Falcon Meadows at Bent Grass Filing No. 4 Transportation Memorandum

Summary of Comments on (Working File) LSC Responses to TIS Redlines.pdf

Number: 1 Author: jchodsdon Subject: Sticky Note Date: 10/7/2022 07:21:55
LSC Responses to TIS Redline Comments

Figure 4  
Existing Traffic

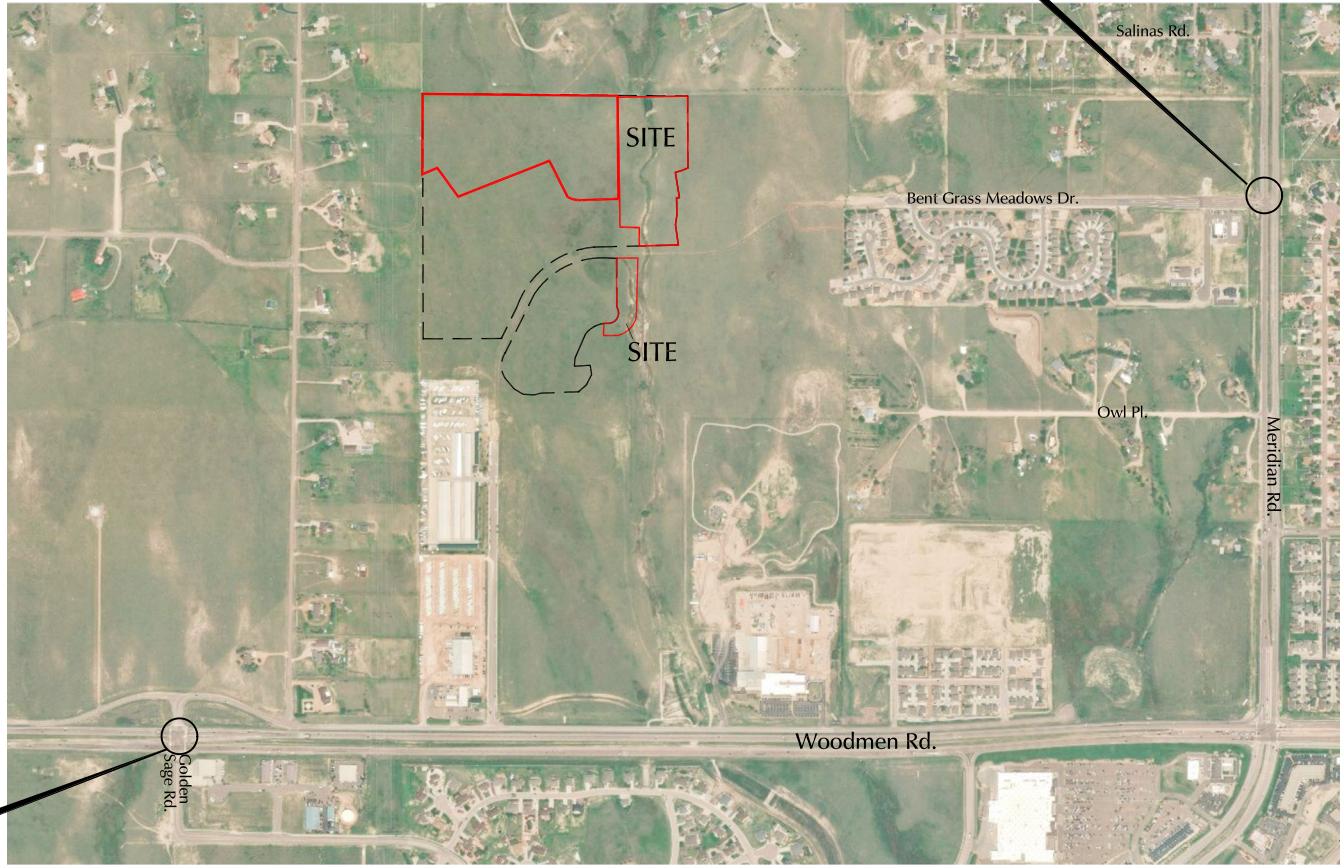
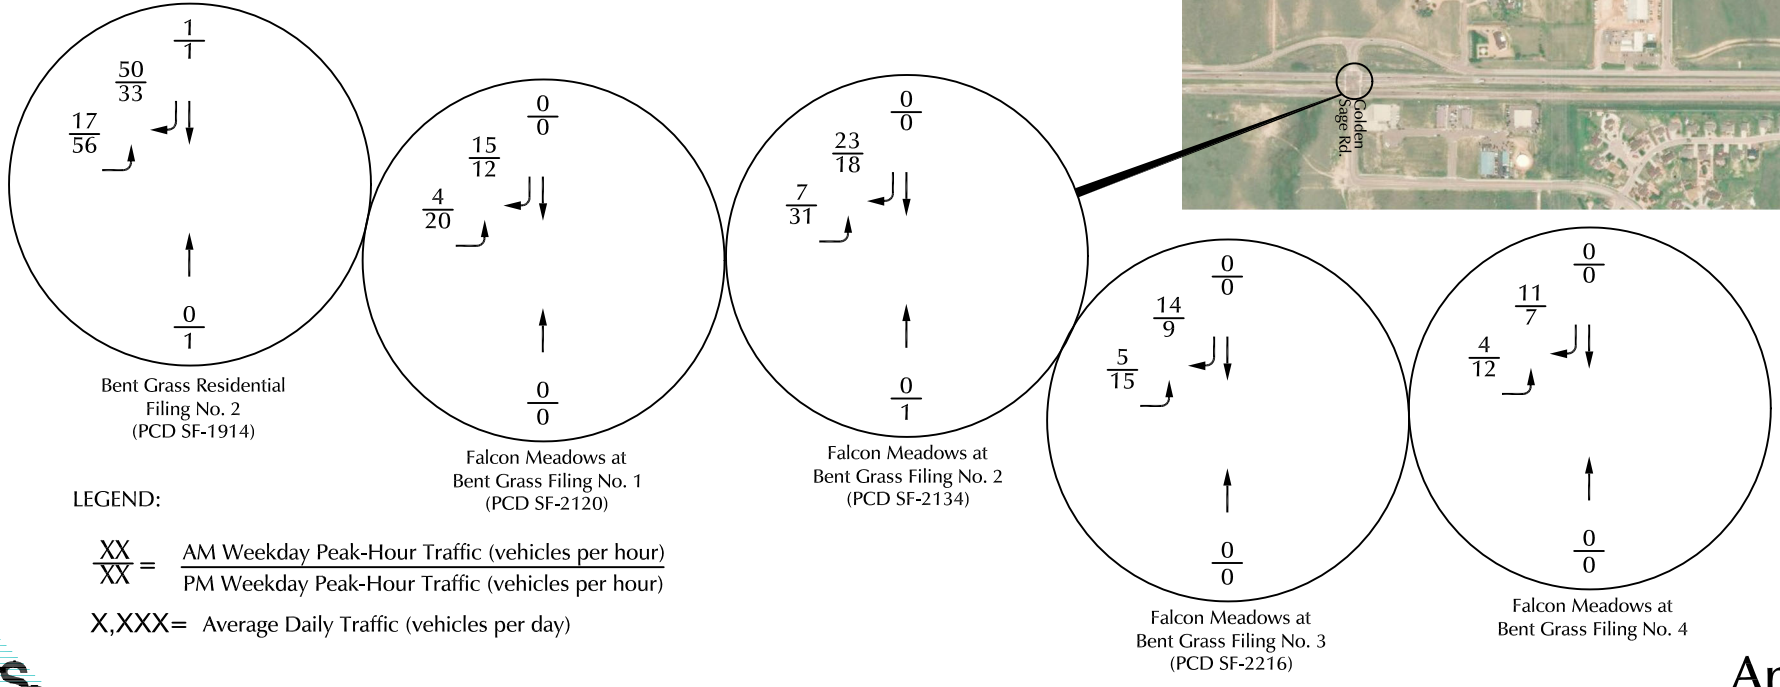
1 Add this intersection

[Add this intersection](#)

Author: kdferrin Subject: Sticky Note Date: 10/3/2022 10:21:15
LSC Response: The additional information has been added to the updated TIS as requested

Figure 5  
**Anticipated Additional Short-Term Traffic Volumes**  
 Falcon Meadows at Bent Grass Filing 4 (LSC #S214333)

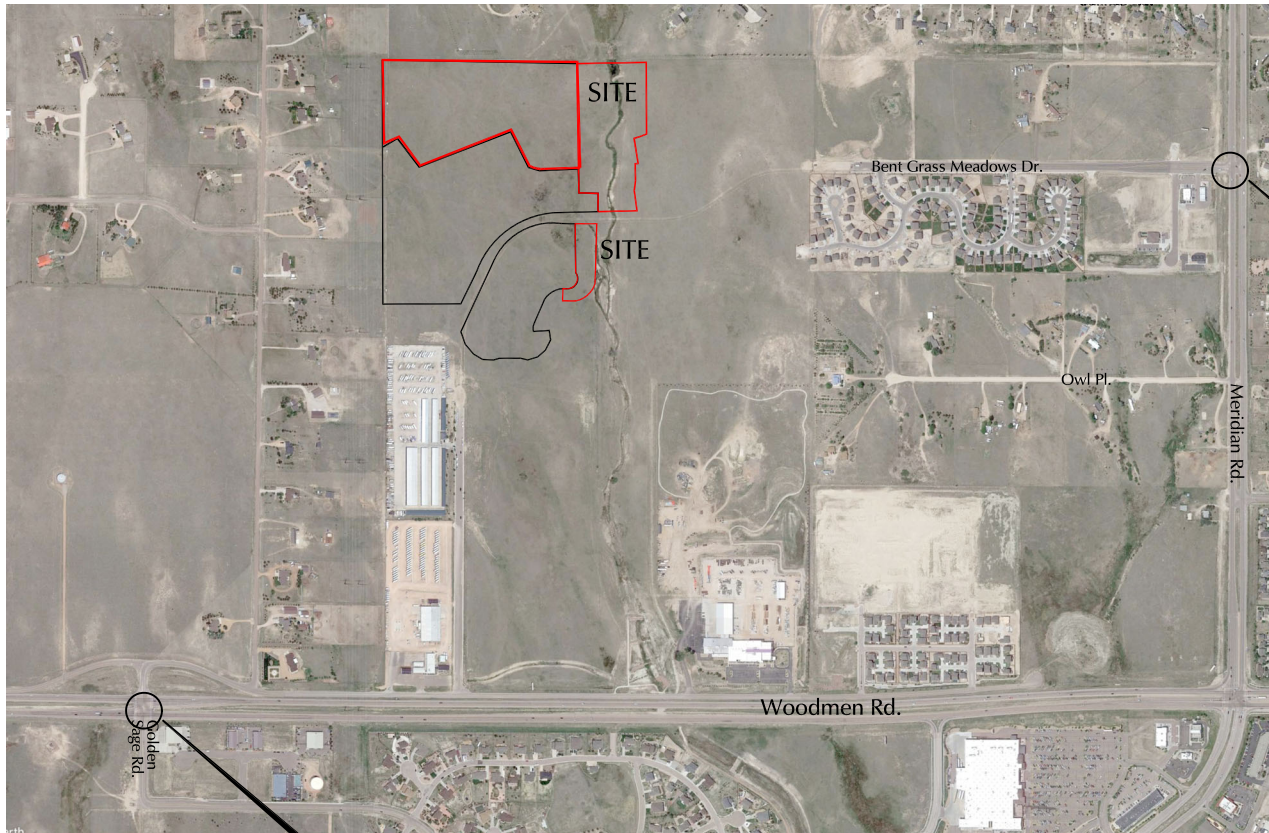
[Add this intersection](#)

Author: kdferrin Subject: Sticky Note Date: 10/3/2022 10:21:18
LSC Response: The additional information has been added to the updated TIS as requested
